About the application

Application number: 2024/92646	
What is the application for?:	Prior notification for change of use from agricultural building to one dwelling
Address of the site or building:	Falledge Farm House, Falledge Lane, Upper Denby, Huddersfield, HD8 8YH
Postcode:	HD4 7NR

SITE PLAN_AS EXISTING
SCALE 1:500

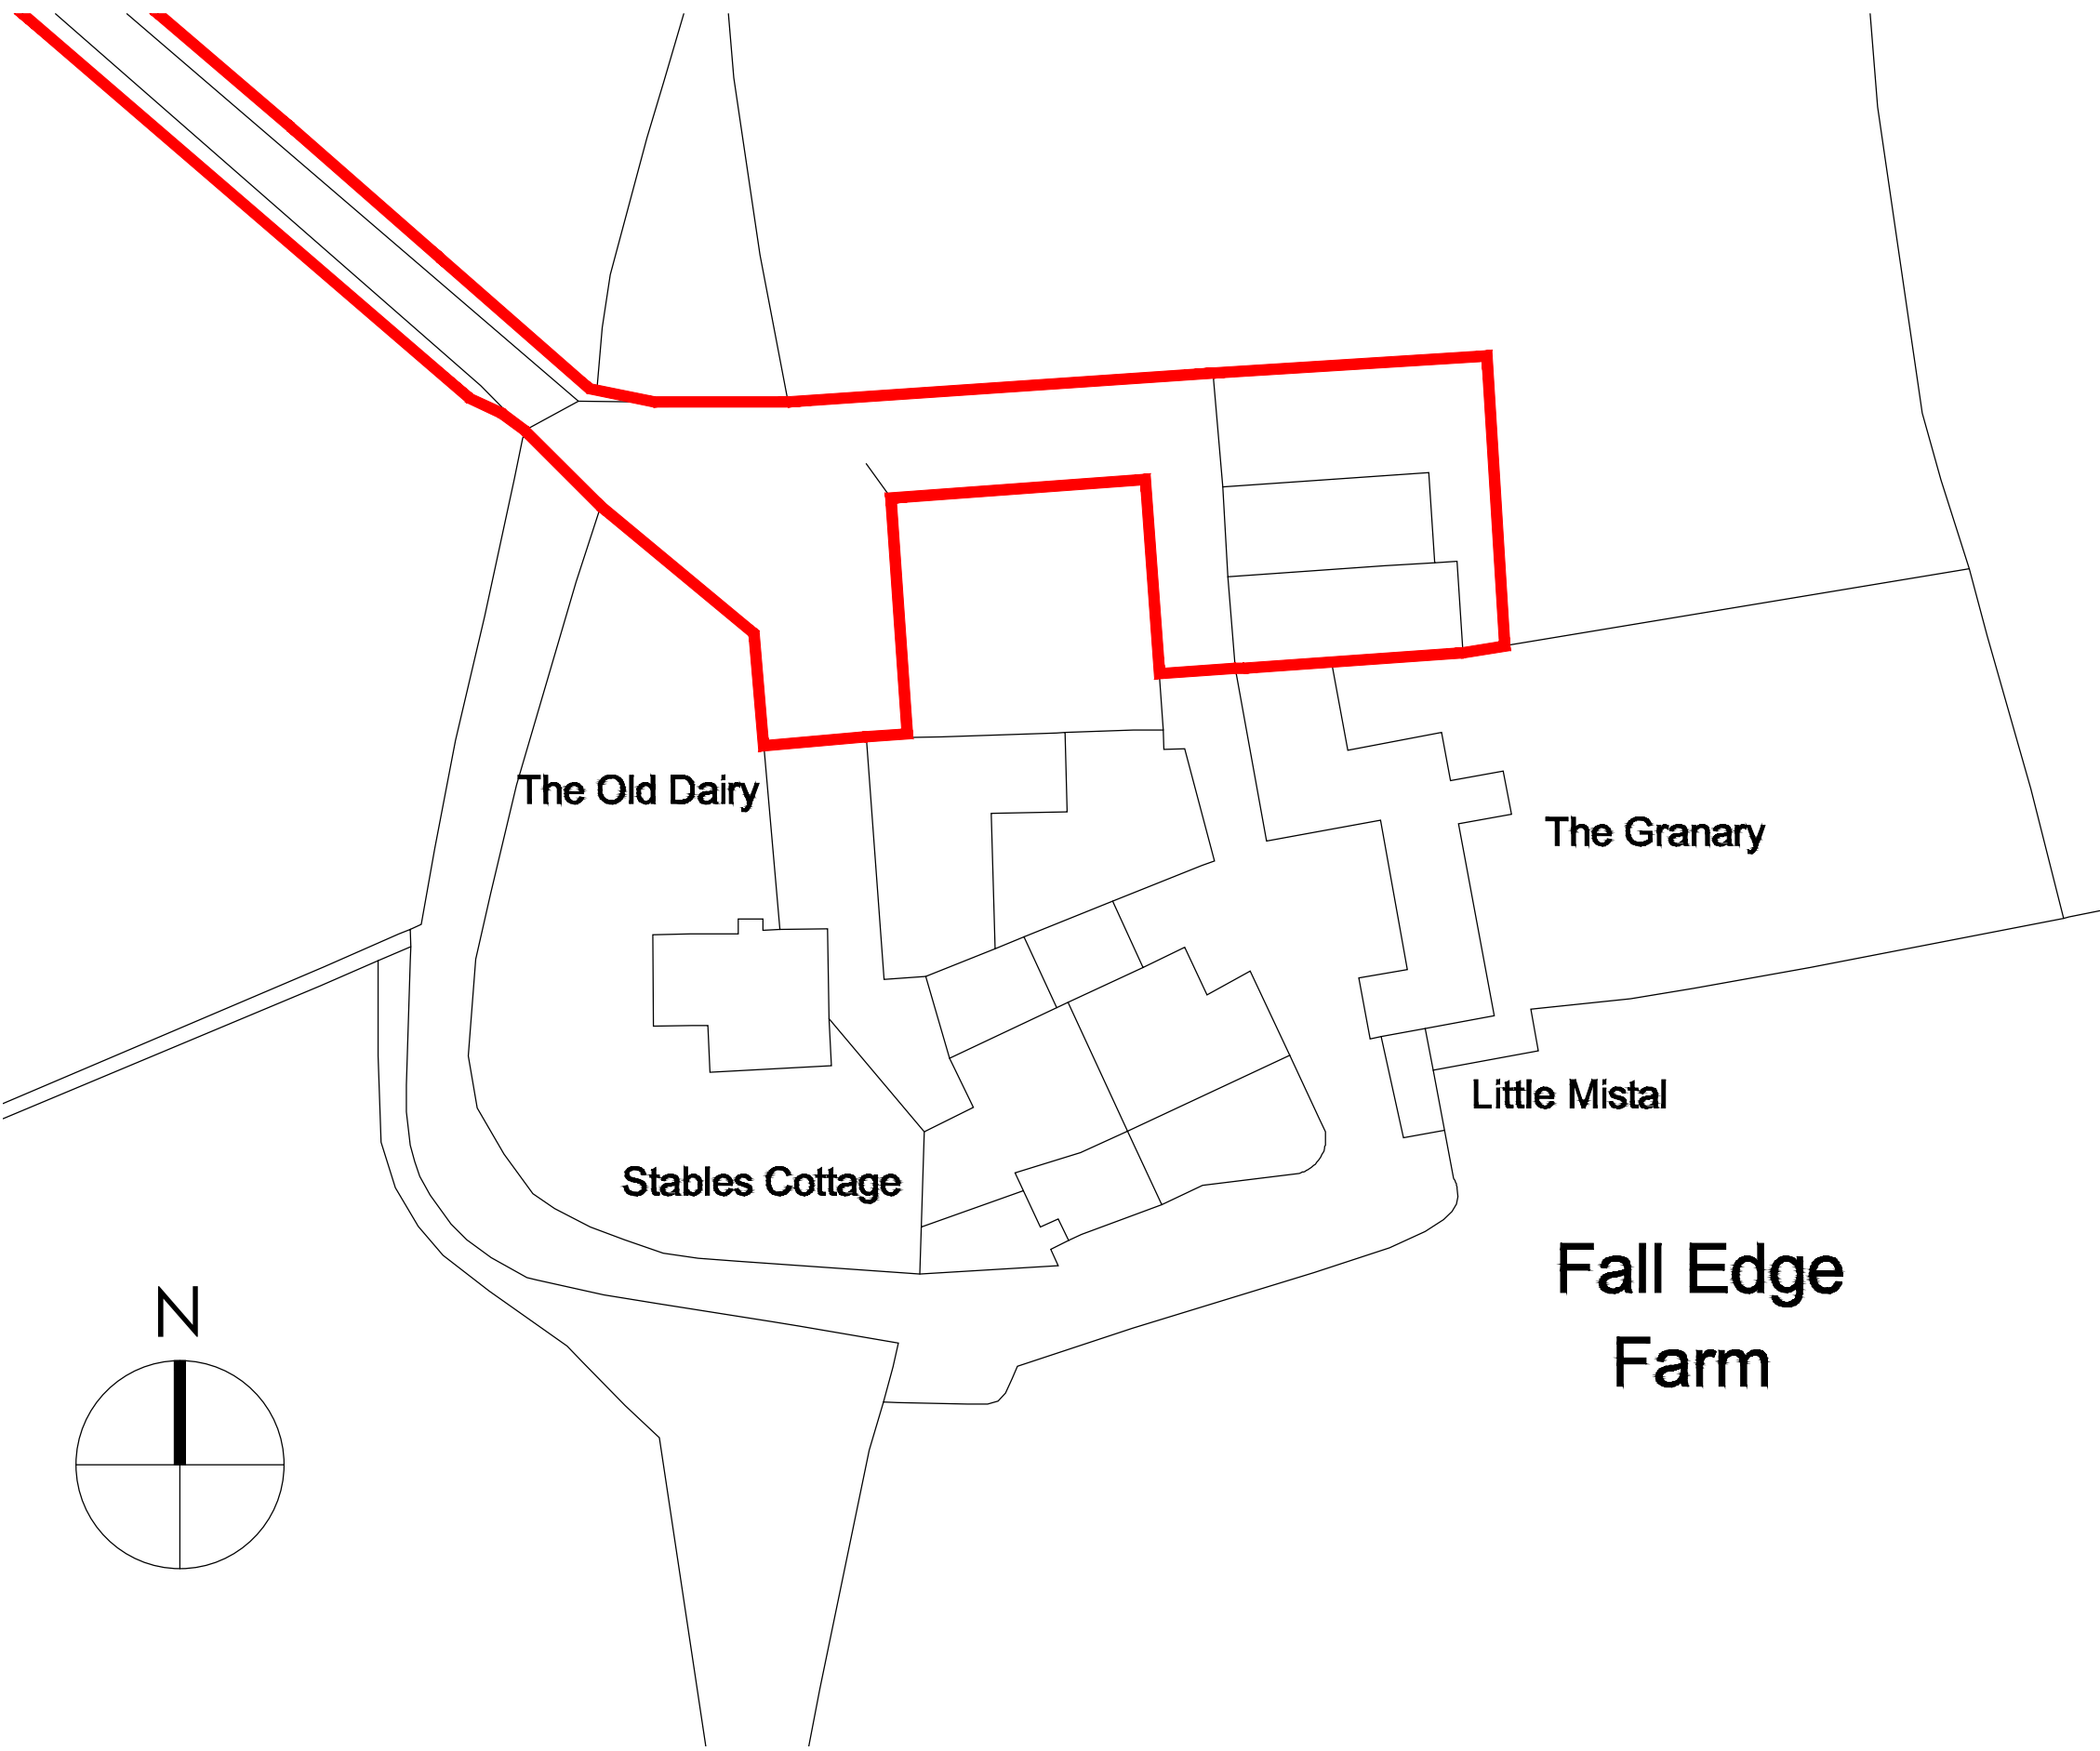
Type of comment: An objection	
Do you wish your comments to be published on the website anonymously?	Yes
There is insufficient very little detail on this application, where is the parking, turning, garden. What are the materials? no bat survey has been submitted. Access is only 4M wide and is serving more than four homes without passing places and visibility onto the road looks very tight, I am concerned this will affect the highway safety near my home. I was also advised by a planning consultant that this building is too large to be converted into a home under a Class Q.
